January 9, 2018

**RE: Titan Presbyterian East Block – Sector Plan Map Amendment and Site Plan for Building Permit  
Project #1011115, 16EPC-40083/40084**

The purpose of this letter is to explain how we have addressed Conditions of Approval for the Sector Plan Map Amendment and the Site Development Plan for Building Permit for this project, located between Central Avenue and Copper Avenue, and Sycamore Street and the future realignment of Spruce Street. The project was approved by the Environmental Planning Commission (EPC) on February 10, 2017.

PED-1

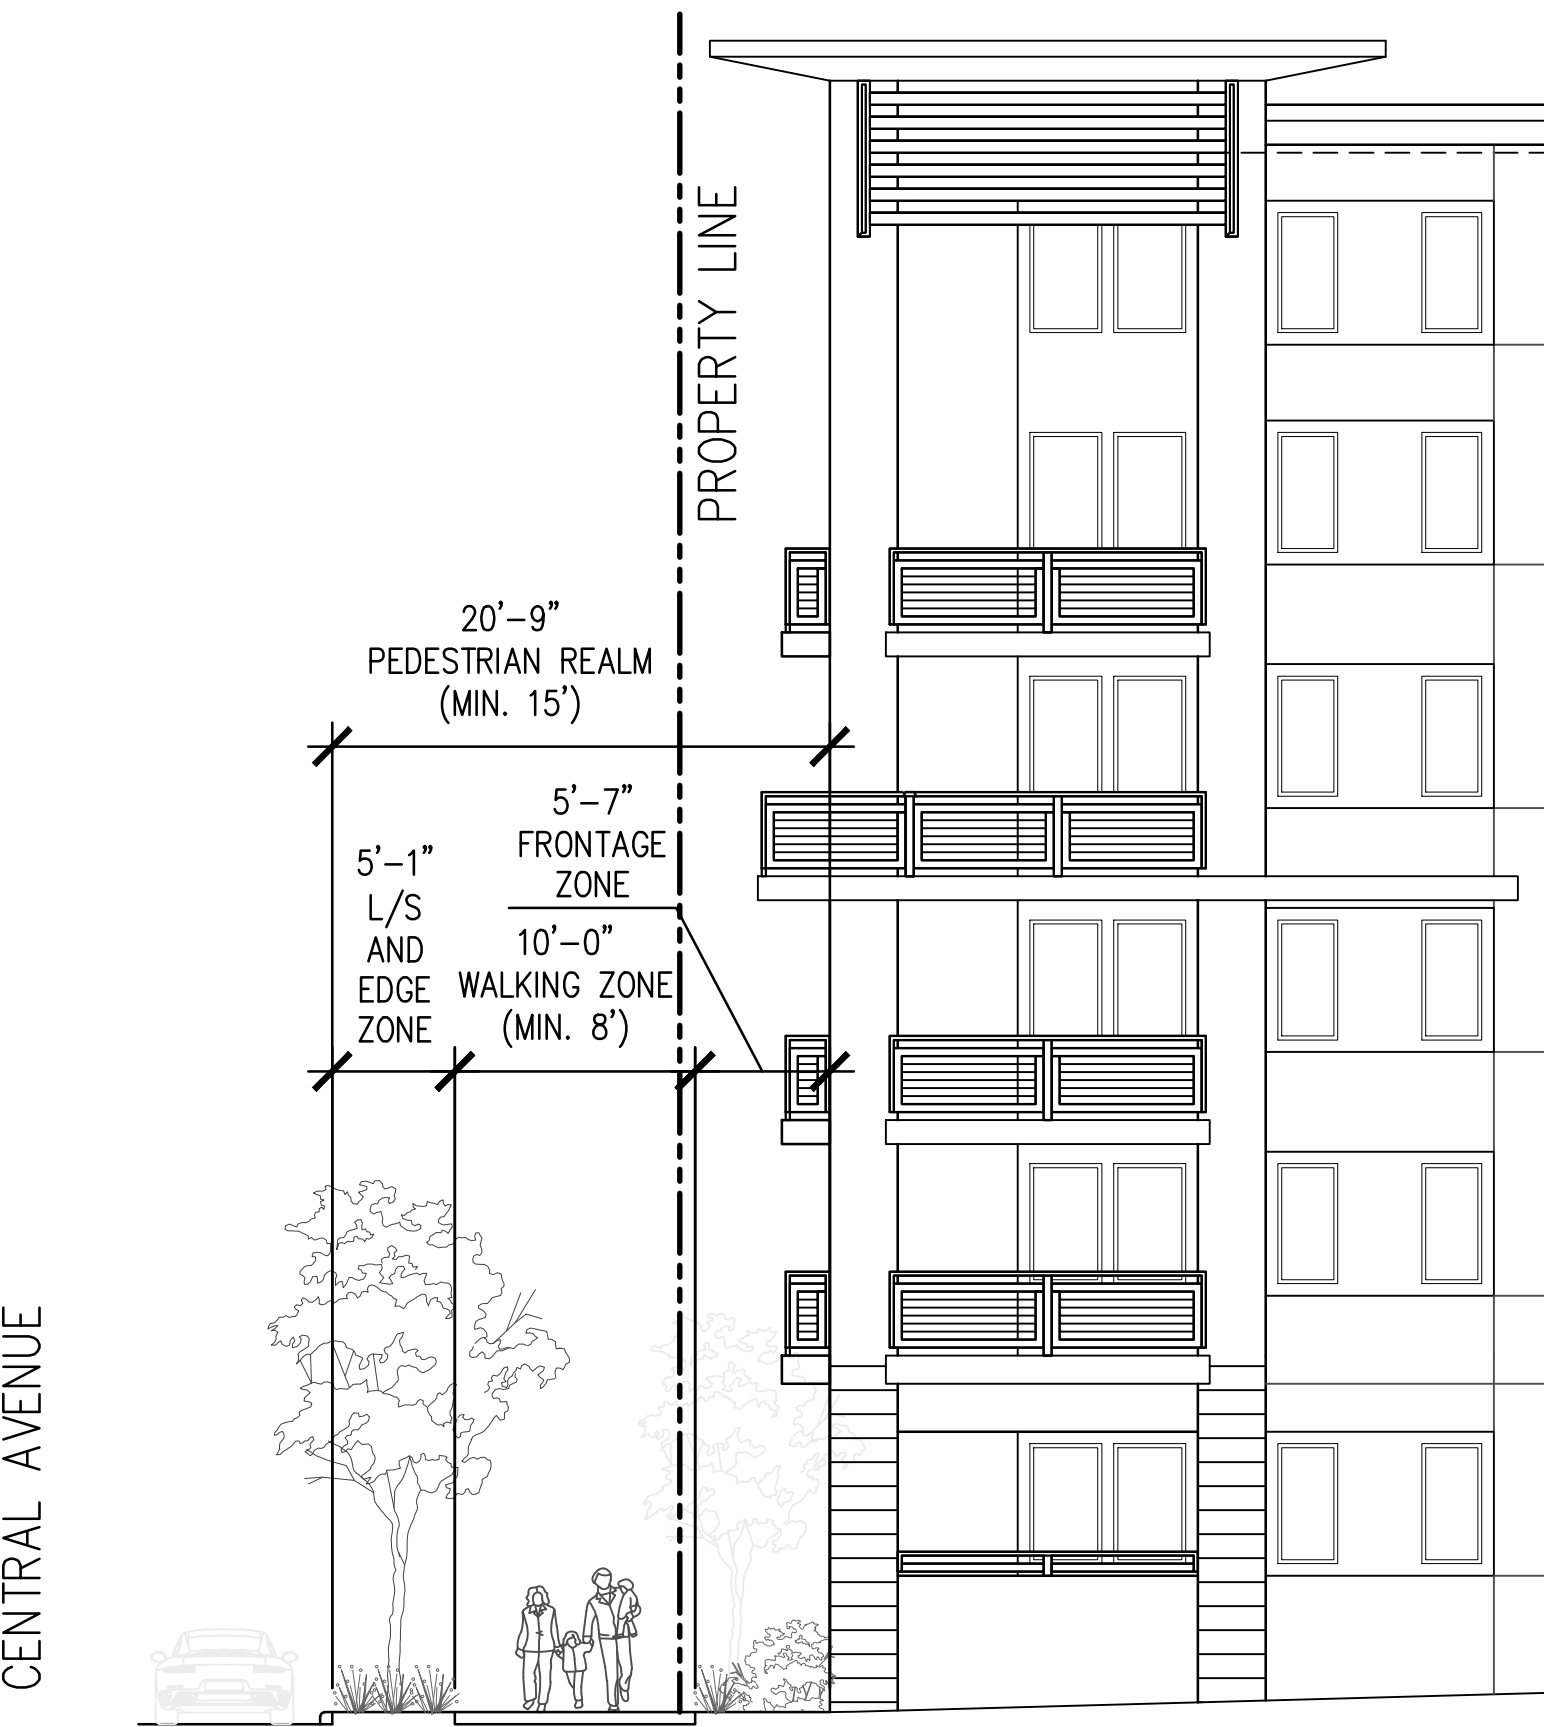
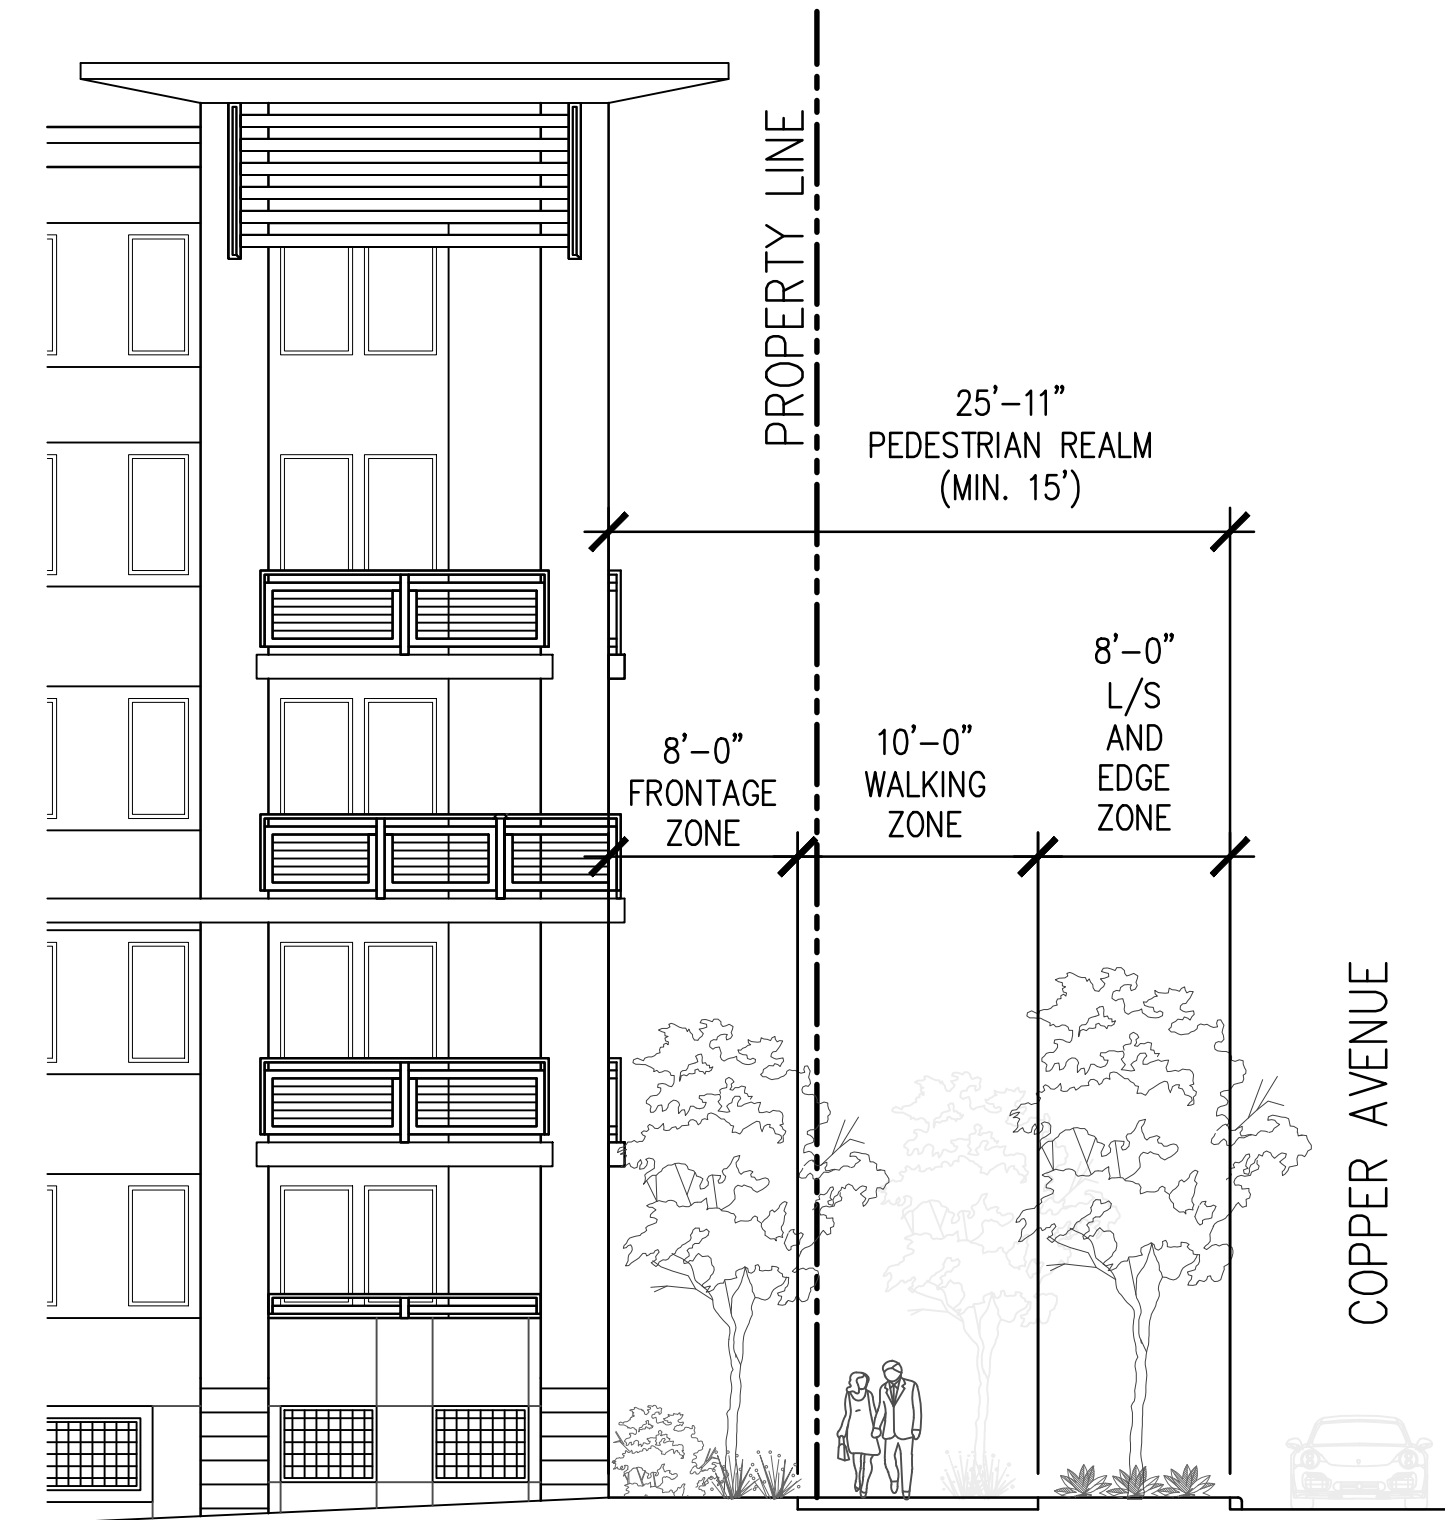
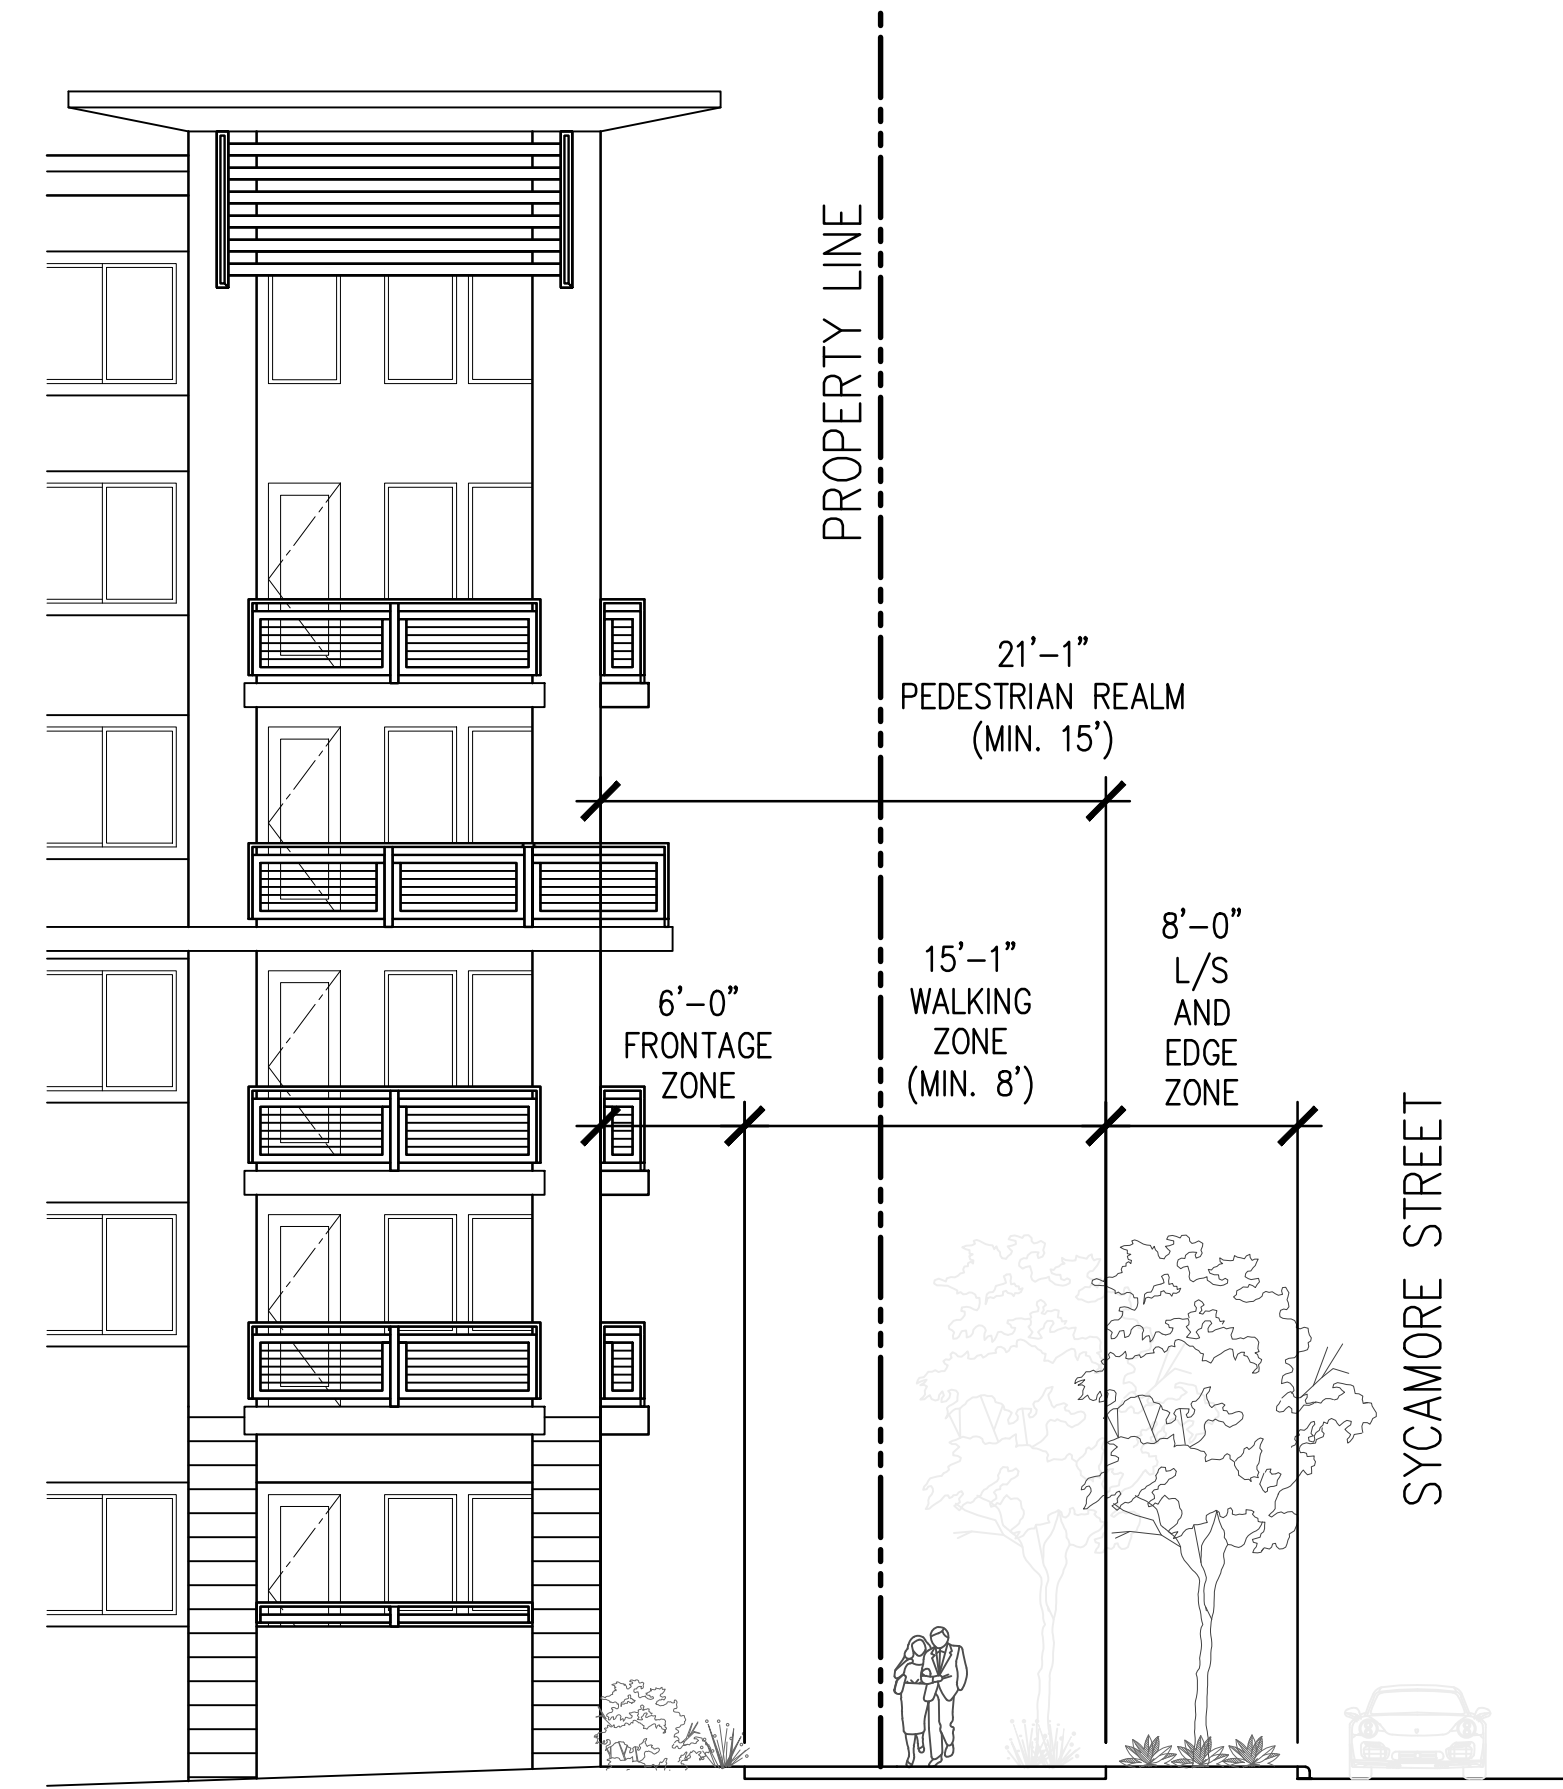
f. On the Pedestrian Realm Exhibits, please update the wording of the LIS Area adjacent to the building to "Frontage Zone" and the LIS Area adjacent to the roadways as "LIS and Edge Zone."

*The wording on the Pedestrian Realm Exhibits has been updated based on this condition. Please see Pedestrian Real Exhibit, Sheet PED-1.*
